FW: WA/18/26/PL Land off Arundel Road - SUB PLAN REQUEST

7428A-PL-05B Accessibility.pdf; 7428A-PL-02G Site Layout.pdf; 7428A-PL-09C Parking.pdf; 7428A-PL-25B Detail Layout.pdf;

Drawing Title  
Accessibility Plan

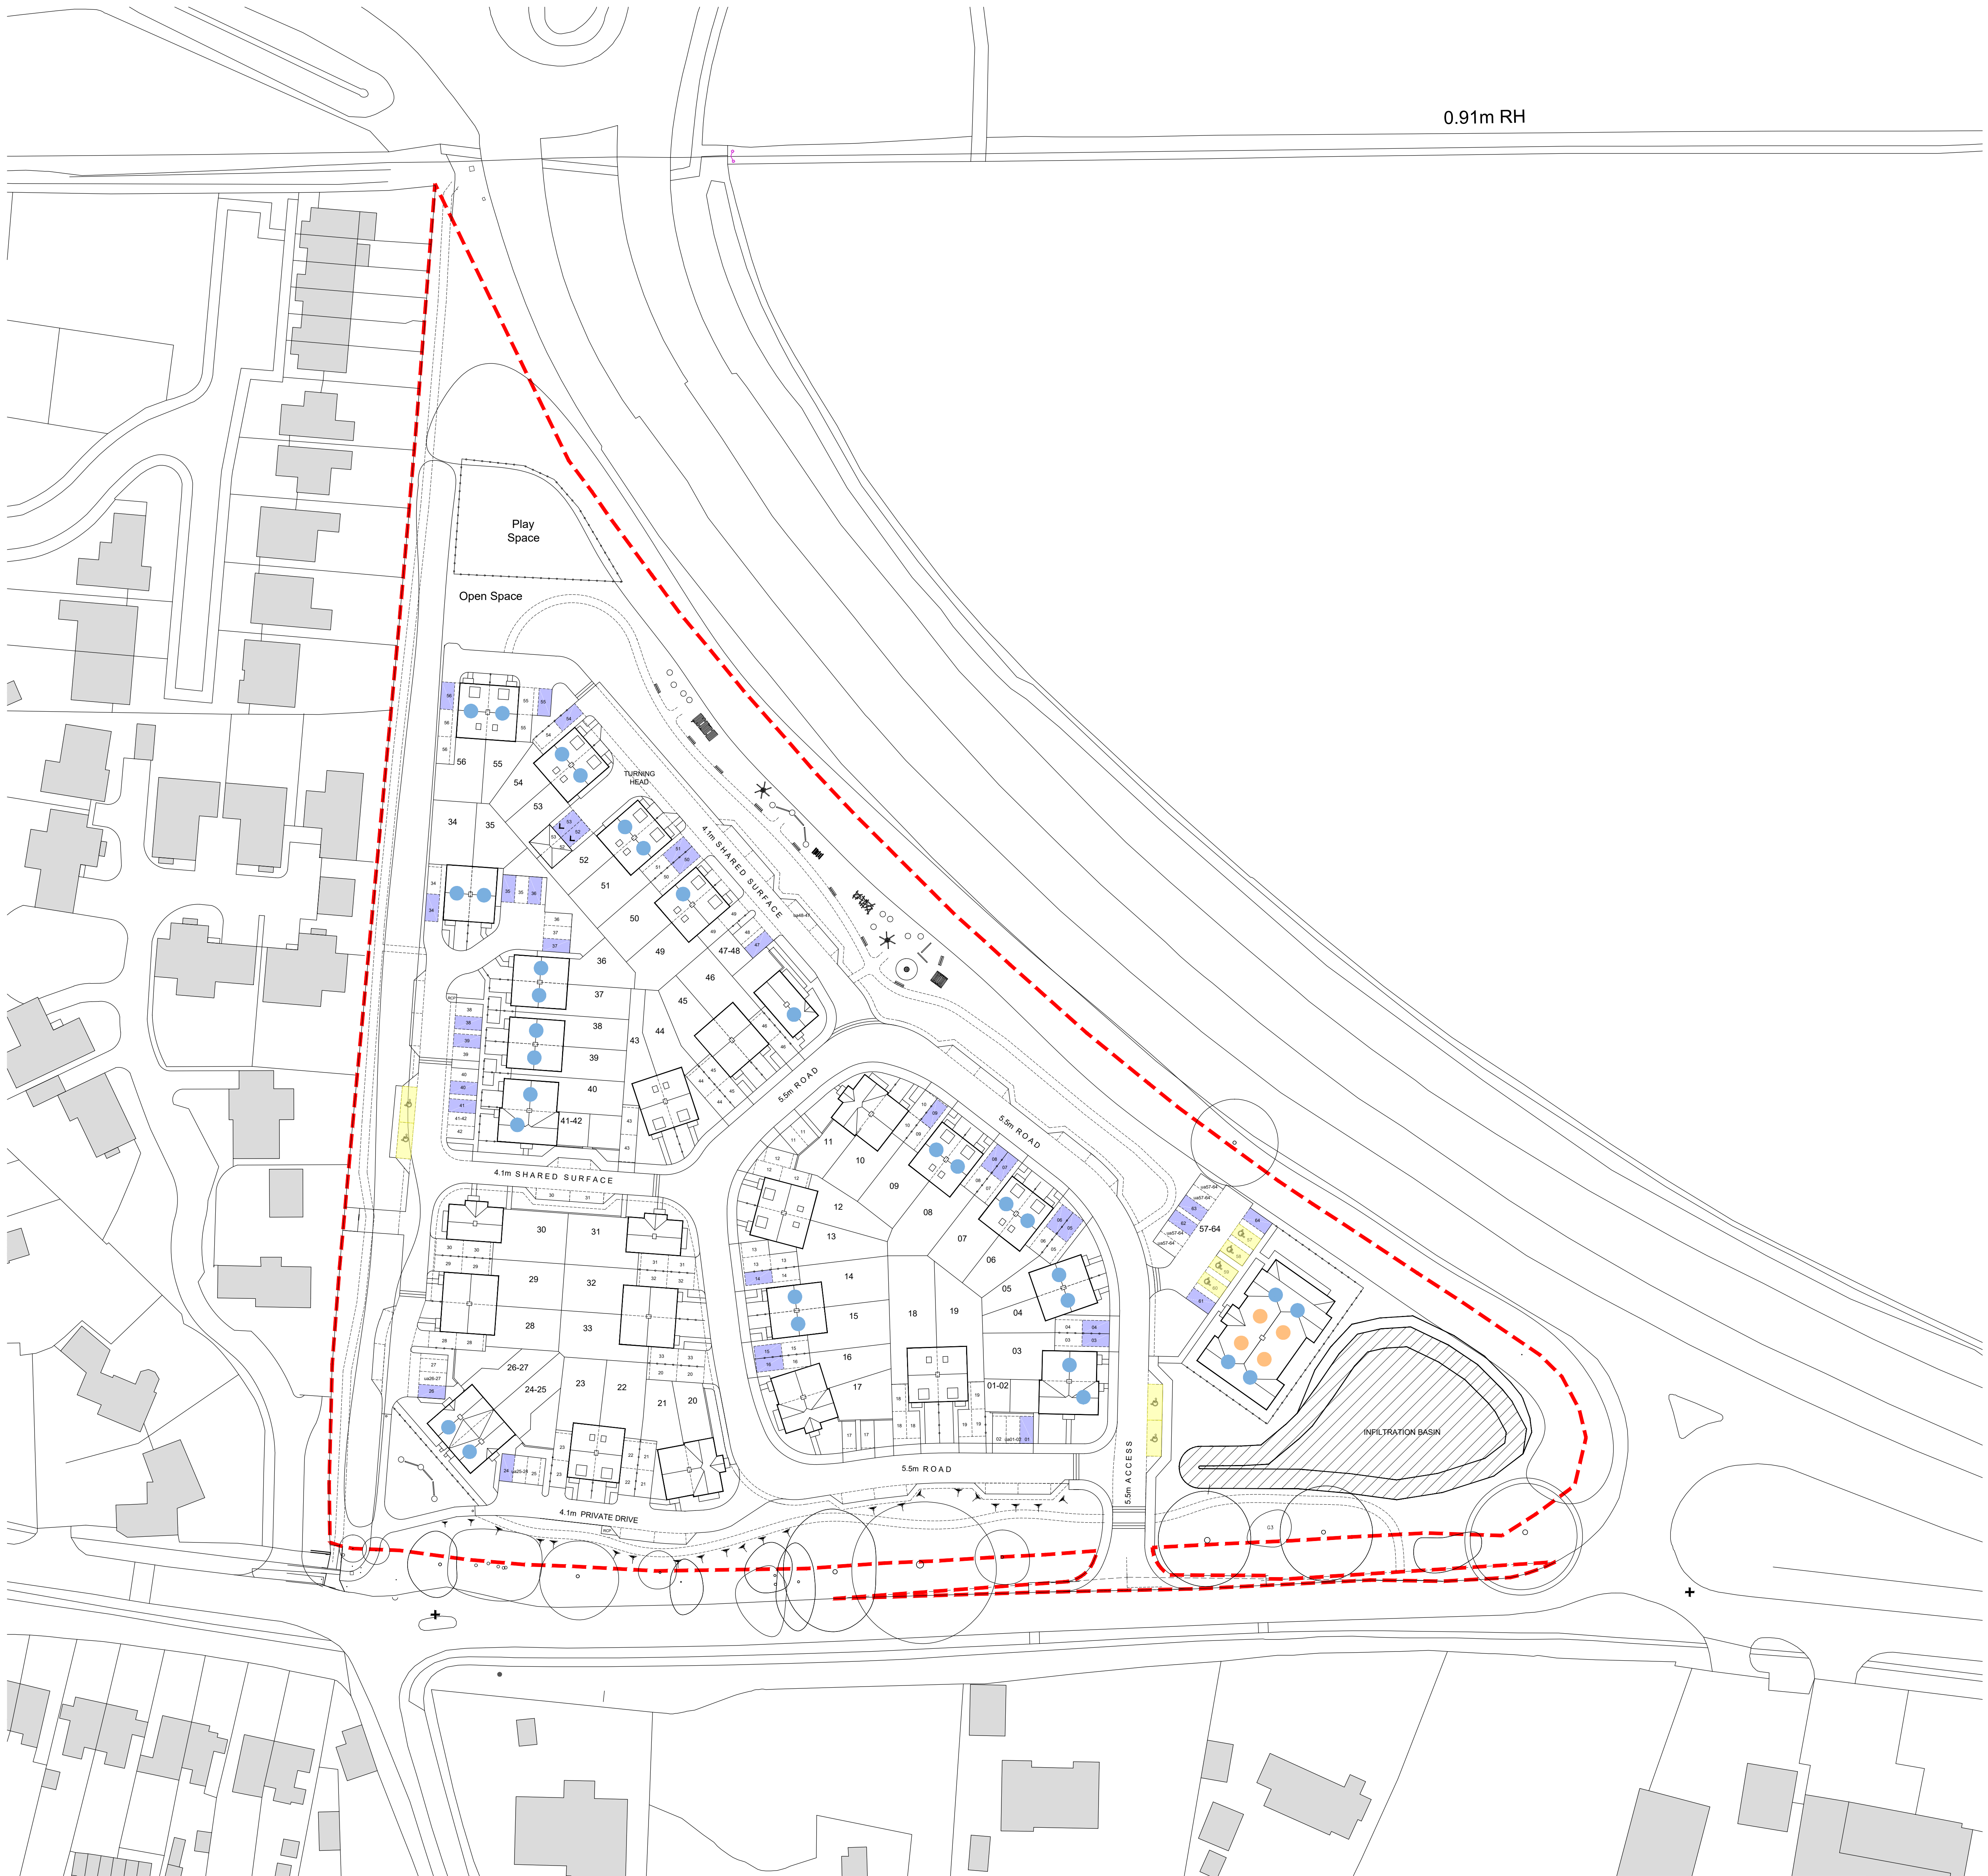
Please see accessibility plan. The annotation on the parking spaces for the maisonettes and flats didn't quite correspond so we have adjusted accordingly to make clear – please see updated drawings. For completeness have also updated the other drawings where these annotations are shown.

Firstly, the quantum of the dwellings listed in the Mix table on p.11 of Planning Statement is 65 homes. Can you advise which part of it is incorrect please. Secondly, its unclear to me which of the proposed 64 dwellings will be M4(2). Can this be clarified. A list of plot numbers would be helpful.

In terms of the M4(2) plots, the plots are:

- Plots 61, 62, 63 & 64 - first floor flats
- Plots 1, 24, 26, 41, 47 – GF Maisonettes
- Plots 3,4,5,6,7,8,9, 14,15, 34,35,36,37,38,39,40,50,51,52,53,54,55,56
